From: Dorothy Planck [REDACTED]
Sent: 29 October 2020 13:32
To: Kathryn Welch <Kathryn.Welch@arun.gov.uk>
Subject: RE: EP/131/20/TC

RG: Tree Works.

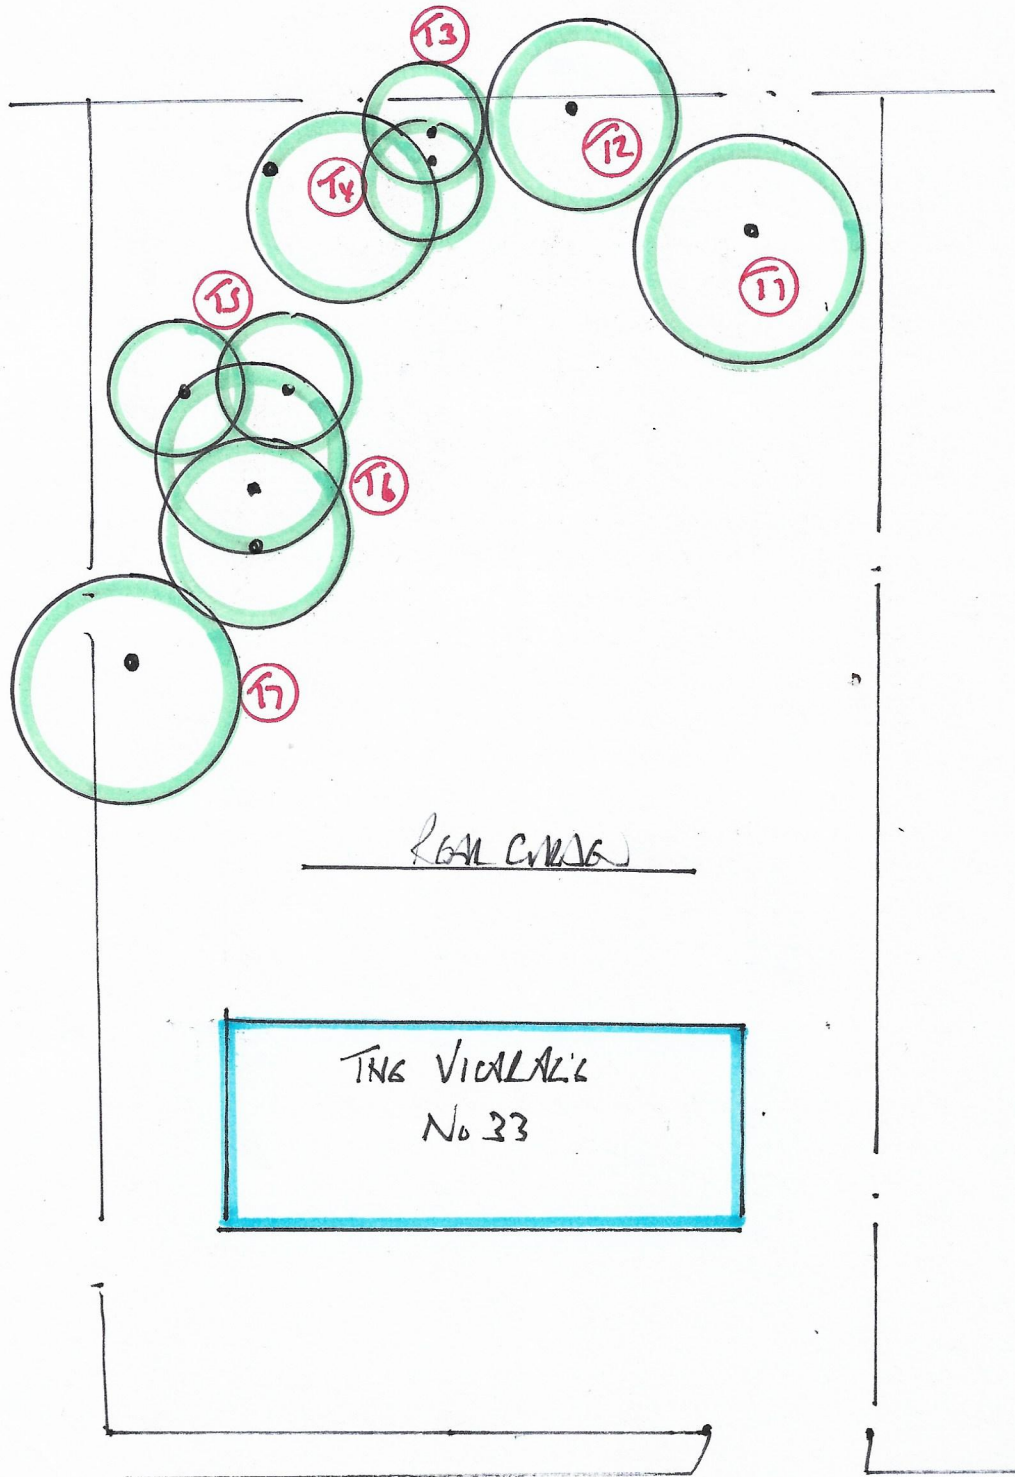
We would require the approximate size of the tree as proposed.
So I would assume, please correct me if I'm wrong, that the Lime tree's proposed size would be; height 17.5m with a spread of 12.5m once the works had taken place, based on the information provided via your recent email and the application form. Could you confirm this for me please.

With regard to the Monterey pine we would require details on the specific branch(s) to be removed i.e. lowest branch to the South West to be removed and/or proposed height of crown to be **m from ground level.

Essentially we are not looking for what you are taking off when it comes to the reduction of the overall height and spread of a tree, we are looking for what will be left behind.

I just want to clarify with you, are the measurements provided the size of the trees now or what your Client is proposing to prune them down to? We require the proposed measurements further to works having taken place.

The tree would be height 17.5m with a spread of 12.5m once work completed on the Lime Tree.
The branch to be removed (as per photograph provided previously) is the hanging branch at 12m to the west side of the tree. The deadwood removal would be general through the crown.

The measurements are the approximate sizes of the trees as they are at the present time.
